Marine Management Organisation

MMO Reference: DCO/2016/00003
Planning Inspectorate Reference:
EN010084
Identification Number: 20012636

28 March 2019

Planning Act 2008, Vattenfall Wind Power Limited, Proposed Thanet Extension Offshore Wind Farm

Figure A 10 Contour plot showing the TTS impact ranges for species of fish (Popper et al., 2014) for both modelling locations for both monopile and pin pile scenarios

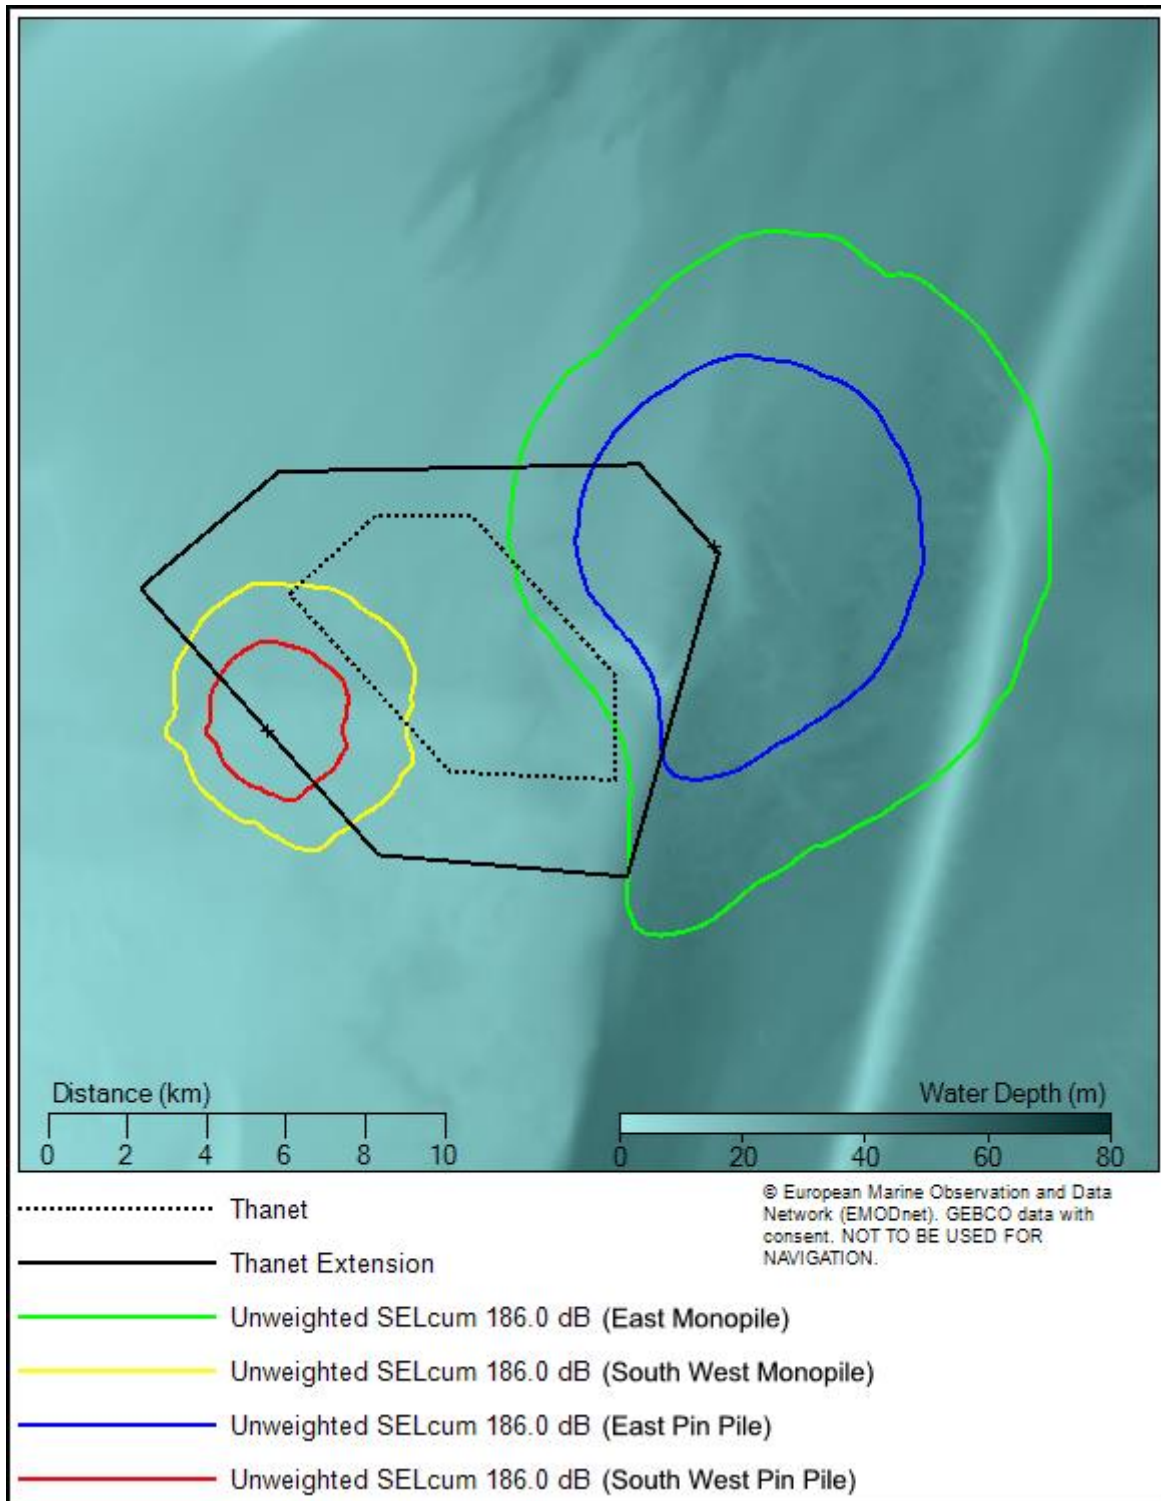
1.2.7 Consequently, the MMO is concerned that the current modelling is not sufficient to fully assess the potential impact on herring spawning areas. Figure 6-14 shows an overlay of the 186 dB re 1 μ Pa²s SEL_{cum} (TTS threshold) noise contours along with herring spawning areas. This figure demonstrates that there is partial overlap between the TTS range and herring spawning grounds (to the East of the site, where IHLS survey data indicates herring larval abundance of between 27,700-50,100 per m²), however this area of overlap is small in the context of the wider habitat available (para 6.10.51). The predicted impact ranges for SEL_{cum}, if based on a stationary receptor, may be larger than this, and may extend into the Herne Bay and/or Eastern channel spawning grounds. However without the modelling presented, the MMO cannot fully assess the potential impact is on these spawning grounds.

1.2.10 Given the potential impacts to and vulnerability of Thames Estuary sole, appropriate modelling is required to determine extent of the potential attenuation of the modelled piling noise (based on a stationary receptor) to and upon sole spawning grounds in the Greater Thames Estuary and whether it extends into known areas of higher spawning intensity. The Applicant’s Environmental Statement (ES) presented an overlay of the 186 dB re 1 μ Pa²s SEL_{cum} (TTS threshold) noise contours along with only herring spawning areas

(ES Figure 6-14). The noise contours have not been overlaid onto identified sole spawning grounds (refer to ES Figure 6-4).

1.2.11 The MMO would therefore welcome a figure being provided with the maximum impact ranges (modelled based on a stationary receptor) that illustrates the potential impact range for injury to herring and sole overlaid against the known active spawning grounds for consideration before it can agree with the conclusions of the ES.
